**Date:** 10/26/2021

**Re:** **Crawl Space 3<sup>rd</sup> Party Foundation Inspection**  
Location: Lot 10 Highland Grove (354 Windy Farm Dr. Fuquay-Varina, NC)  
JDS Project No.: RDU2111142  
Municipality: Fuquay Varina  
Date of Inspection: 10/25/2021  
Permit No: 21040017

CRAWL SPACE  
 FOUNDATION PLAN  
**S.30C**

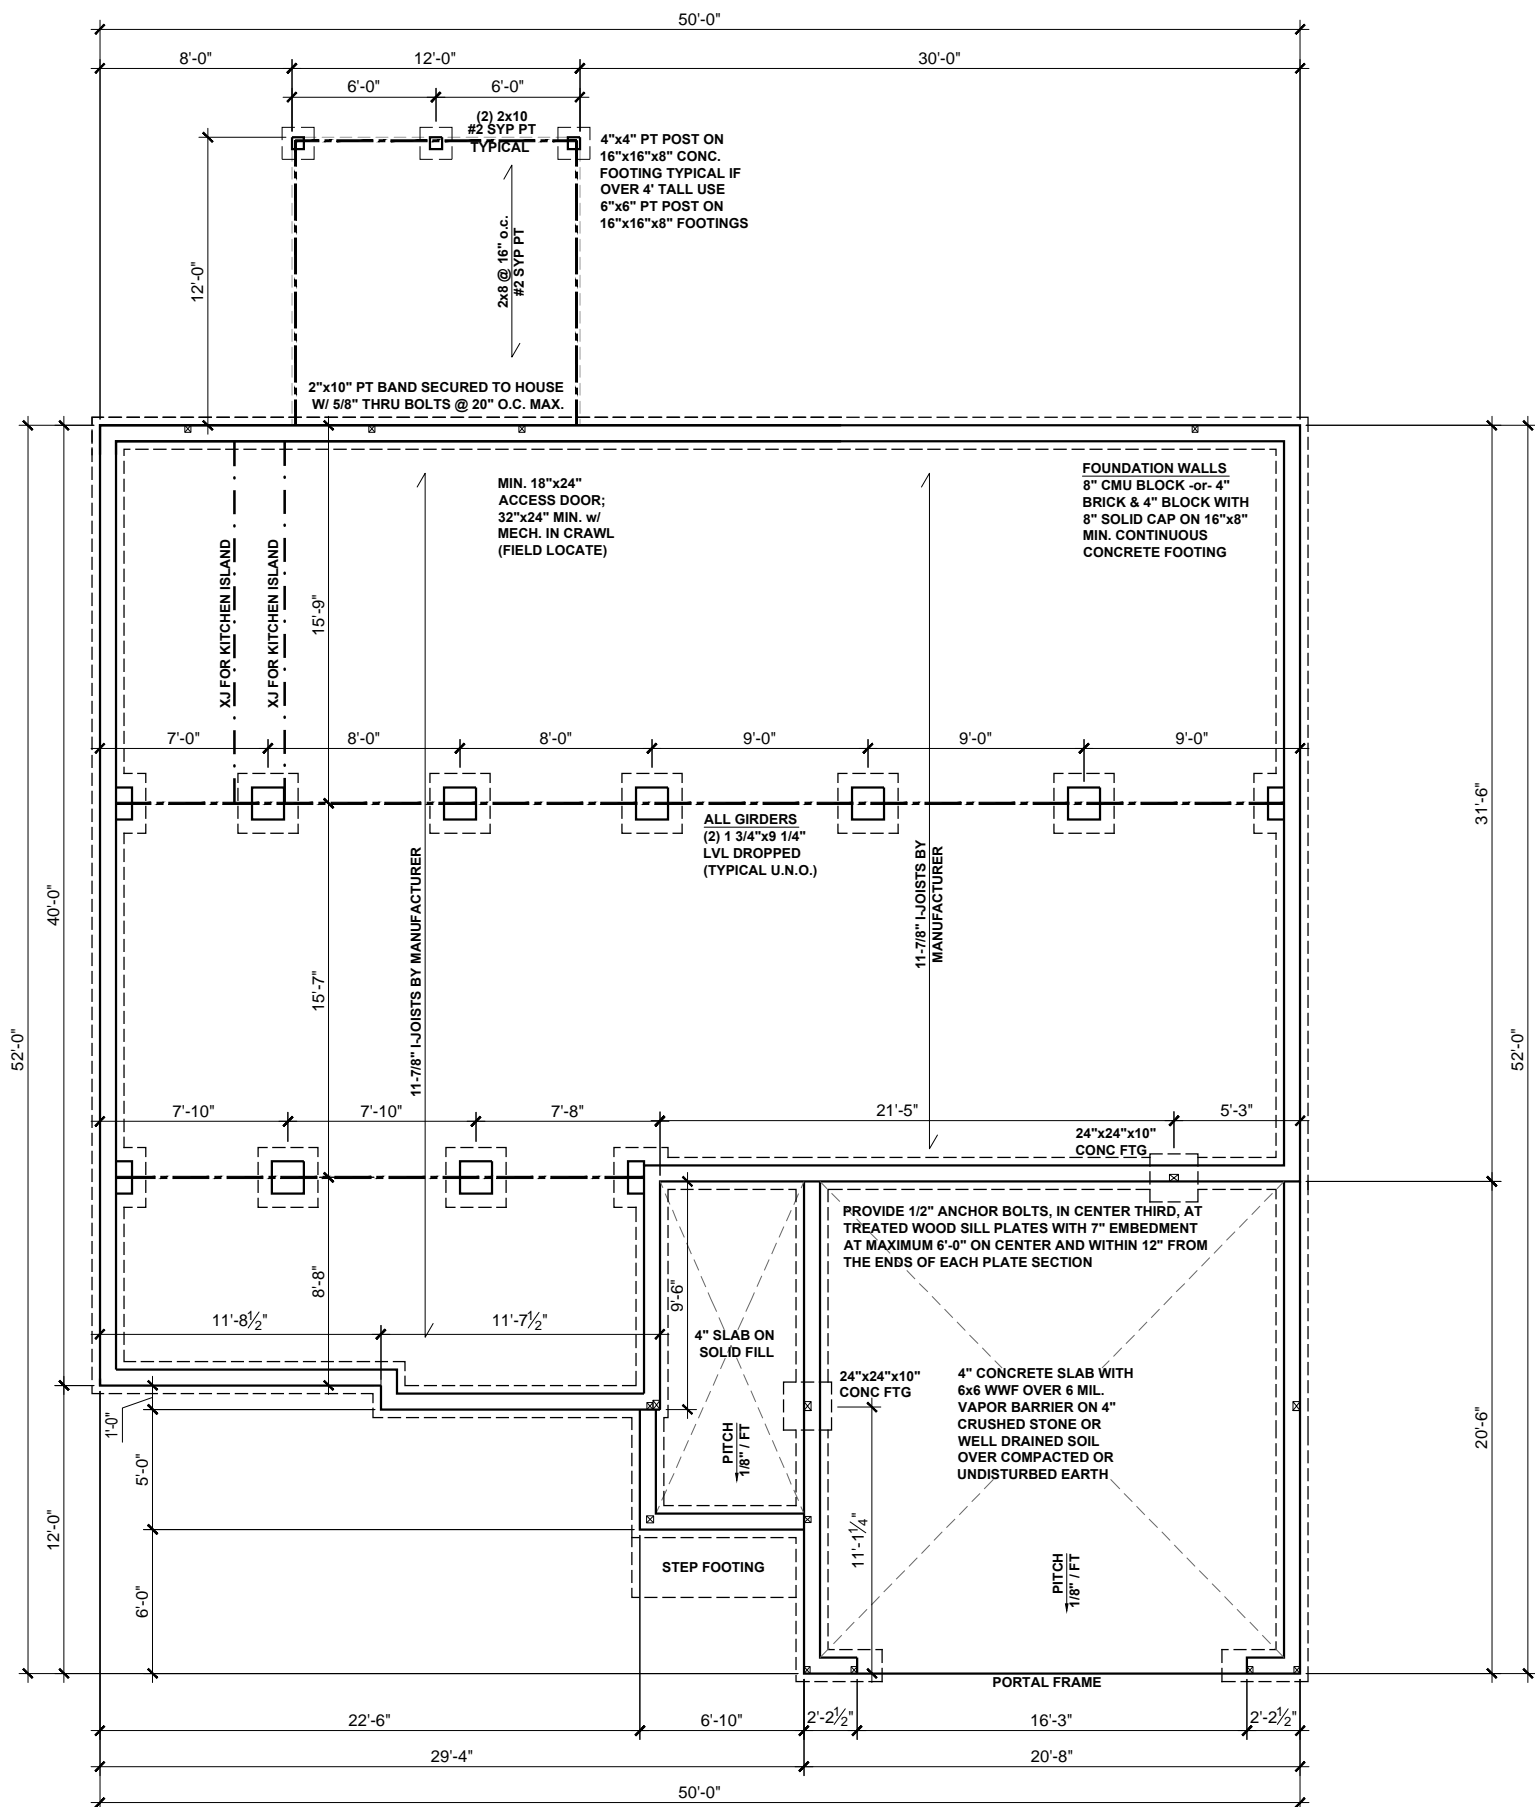
- Perimeter walls have a minimum 2" projection on both sides.
  - On site, the foundation has been backfilled preventing full evaluation of foundation projection. Approximately (19) locations have been dug back exposing the footing below. Projection was verified at (19) locations with use of a probe rod.
- Piers are properly sized and placed per the structural drawings.
- All piers bear on the middle third of the pier footings.
  - Pier location on footings could not be verified. (1) face of each pier has been exposed in lieu of (4) as depicted on the approved marked up foundation sheet.
- All mortar joints have been struck or tooled and have proper consolidation.
- Unbalanced fill conditions for the porch and garage are acceptable.
- Anchor bolts could not be verified at sill plates or garage wingwalls.

Based on our on-site observation and review, the contractor should expose foundation piers as described on the approved marked up foundation page provided by JDS Consulting.

**GARAGE WING WALL** 3/8" = 1'-0" **9**

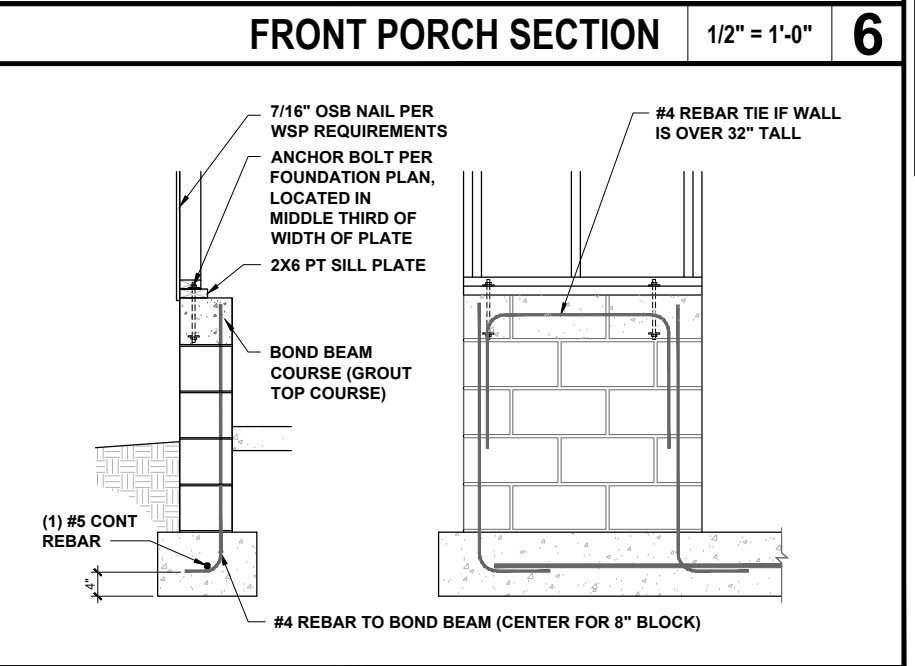
The footings and foundation were constructed at time of inspection. This was a limited visual inspection of the foundation already in place. Construction methods used at garage wingwalls could not be verified. The municipality should provide verification or documentation that the garage wingwalls has minimum (2) 5/8" threaded rod in lieu of the details in the permitted plans because the municipality approved the framing.
